KITTITAS COUNTY FIRE MARSHAL'S OFFICE

April 17, 2026

Fire Marshal comments
Kittitas PUD HQ
SE-26-00003

OVERALL SITE PLAN

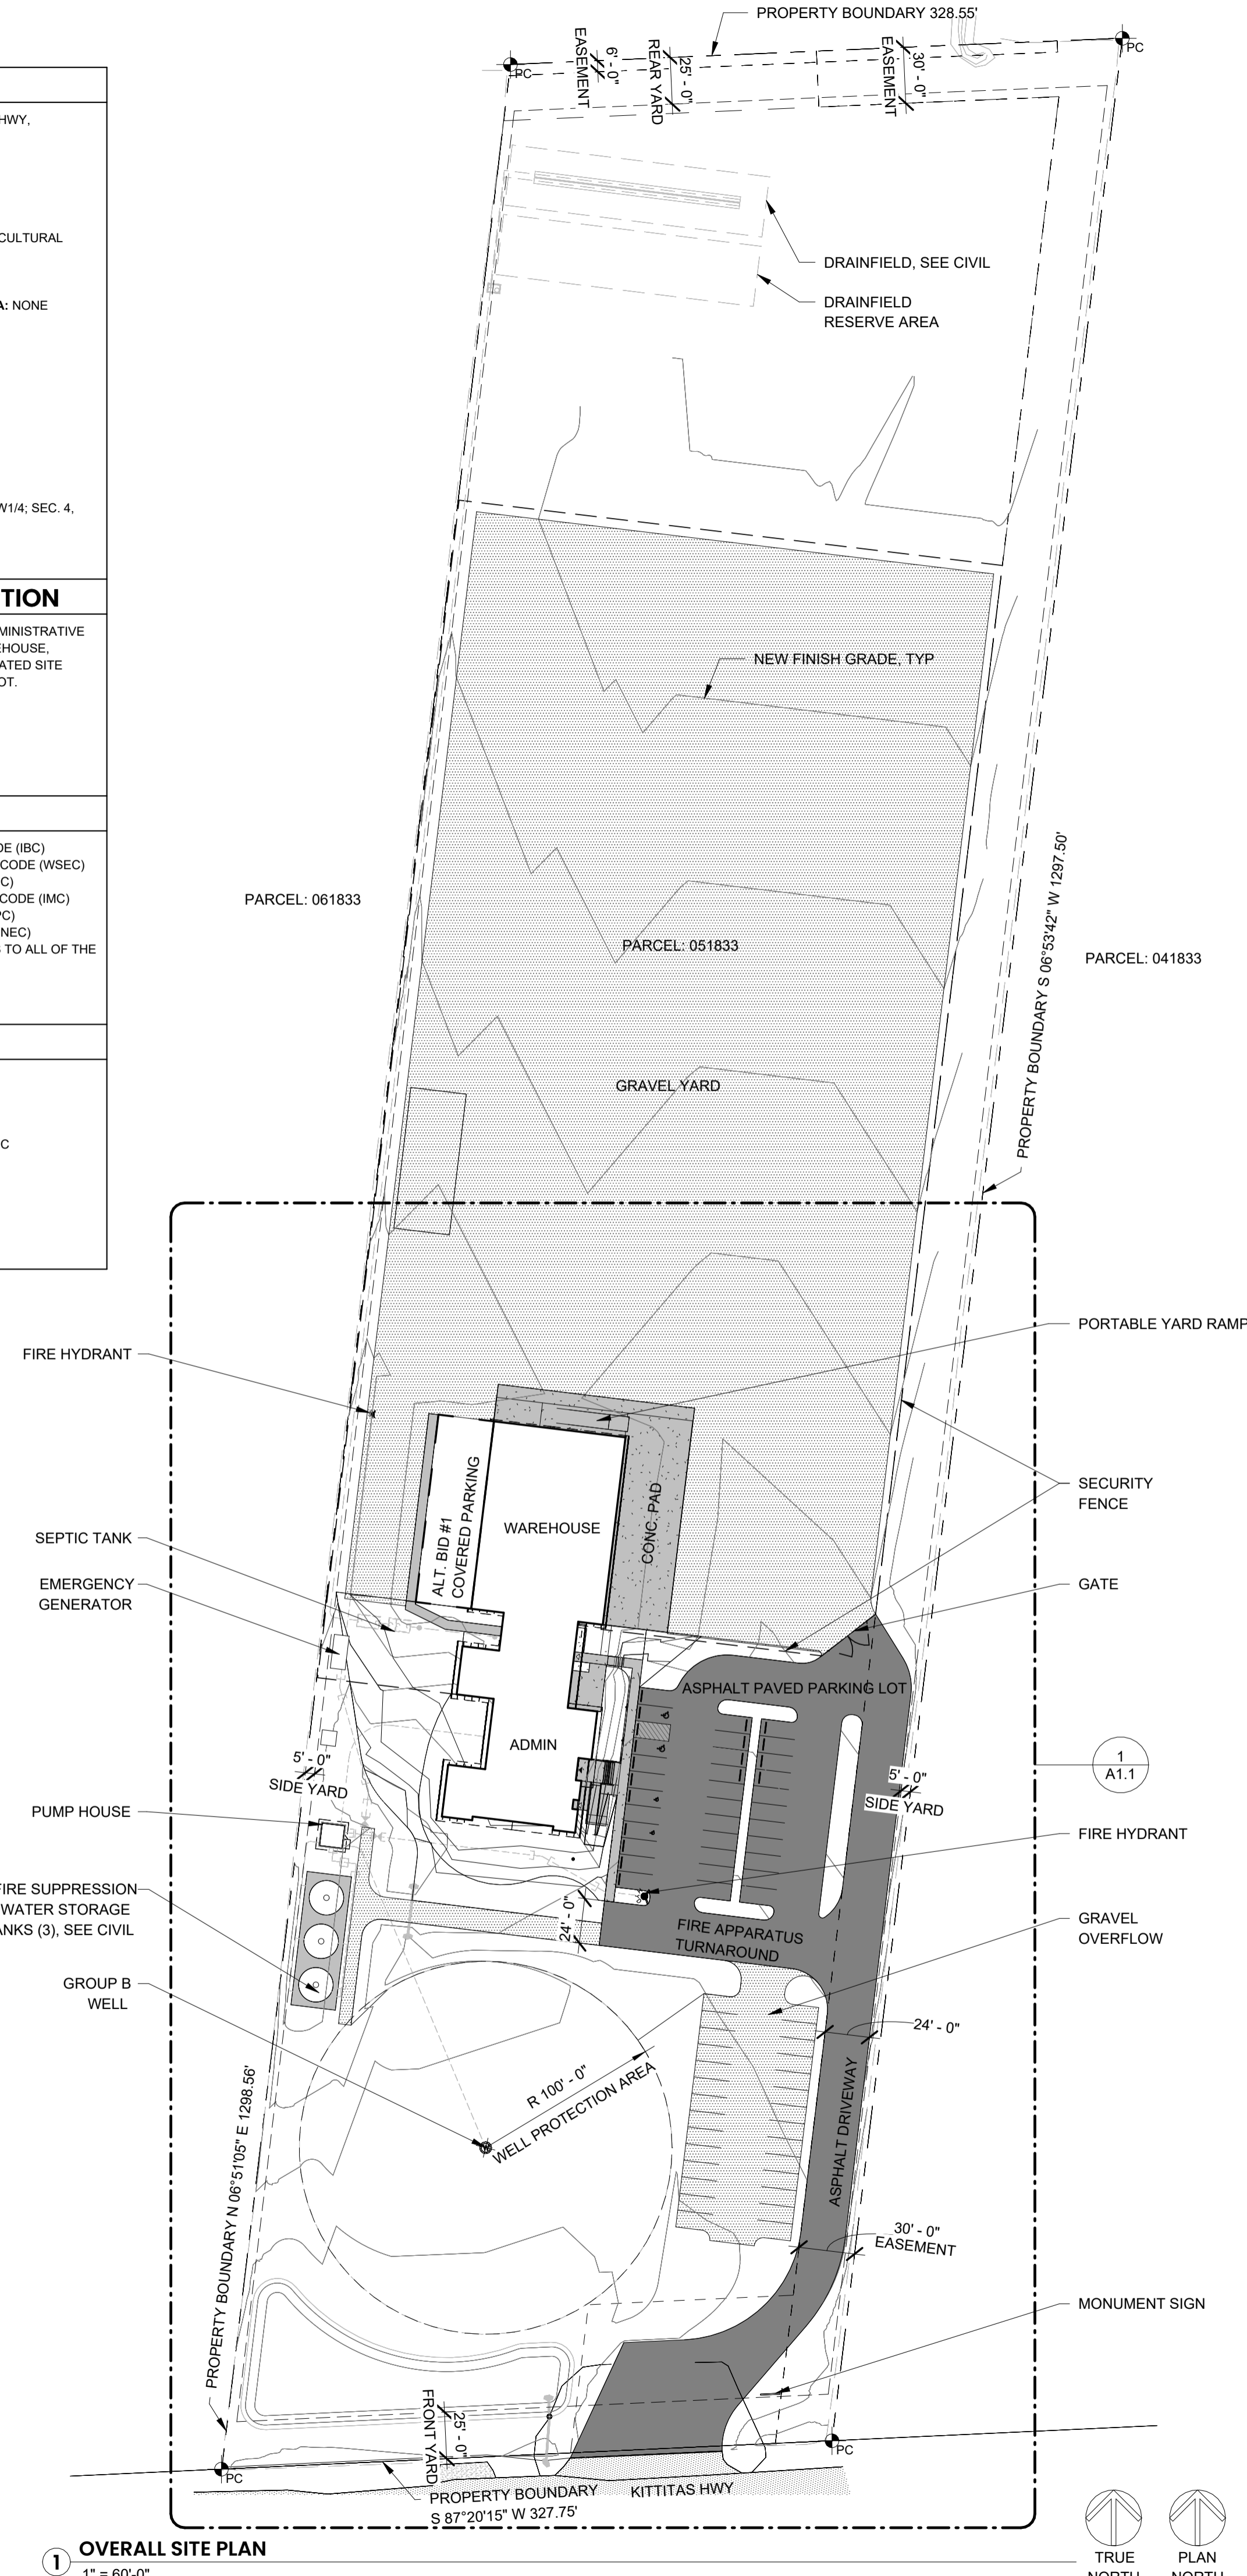
Fire hydrants are required for this application. The indicated number and spacing of the fire hydrants is adequate.

Fire apparatus access is required for this application. The roadways and maneuvering areas as indicated in the application adequately provide required fire apparatus access. Provide fire apparatus access roads with an unobstructed width of not less than 20 feet, an unobstructed vertical clearance of not less than 13.5 feet, with an all-weather driving surface and capable of supporting the imposed loads of fire apparatus. Access roads shall extend to within 150 feet of all portions of the facility and all portions of the exterior walls of the first story of the building.

Approved fire apparatus turnarounds are required for this project. The indicated provisions for turning around fire apparatus are adequate.
